OUTLINE

Reference:	H09-0034-17	Date of Decision:	8th May 2017
Applicant:	H A Architectural Services Ash House 3a Whitwell Road Empingham Oakham Rutland LE15 8PX		
Location:	Paddock Between 1 Paddock Lane/Campling Place Holbeach Bank Spalding		
Description:	Proposal of 56 new sustainable dwellings comprising 28 affordable homes and 28 open market homes together with provision of New Community Village Shop

South Holland District Council hereby give notice that this application has been REFUSED for the above proposal for the following reason(s):

Site Layout Plan

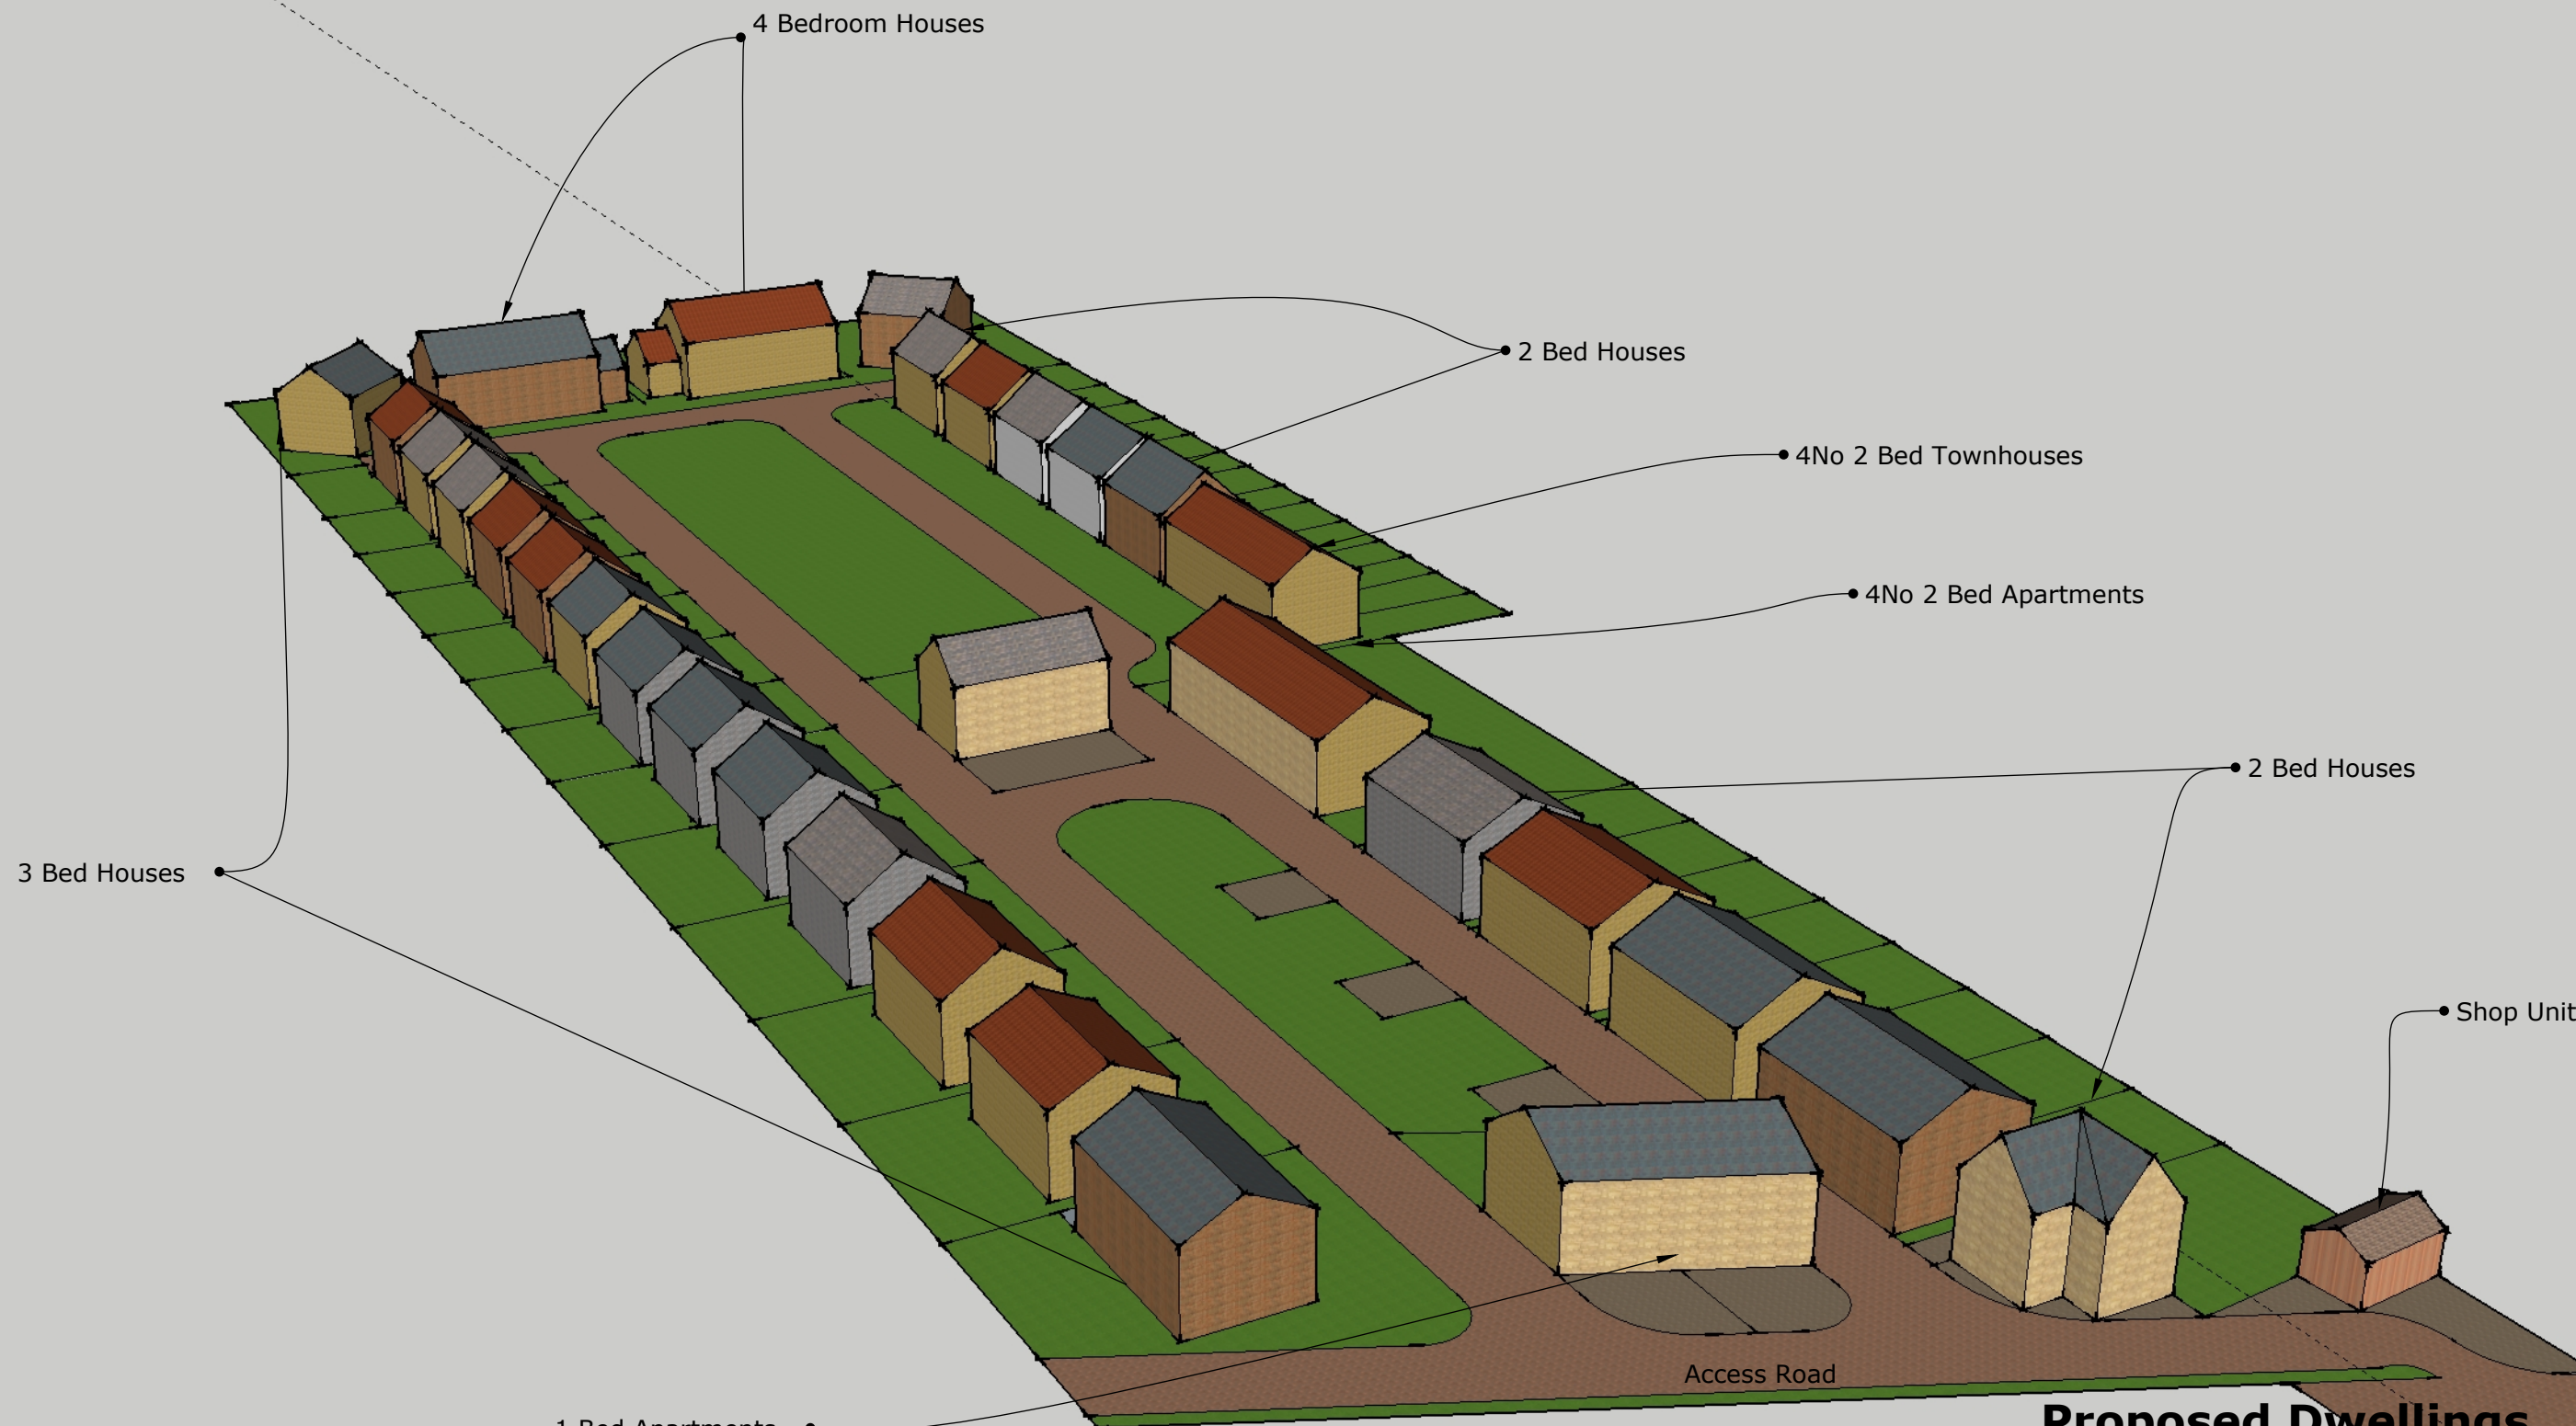
- 3 Notwithstanding the Council's current lack of a 5-year supply of deliverable housing sites, the presumption in favour of sustainable development enshrined in Paragraph 14 of the National Planning Policy Framework, 2012 does not apply in this instance due to the layout of the development. The internal loop-shape road is uncharacteristic of the adjacent residential settlements (dwellings accessed from Star Lane/ Campling Place and Roman Bank) and the footprint of the development in relation to the given dimensions of the site (1.2 hectares) and the existing boundary constraints might be too large, resulting in such a high density that would have an adverse effect on the character and appearance of the locality. It is therefore considered that the proposal would have an adverse effect on the character and appearance of the locality, in contravention of Policy SG15 of the South Holland District Council Local Plan 2016.
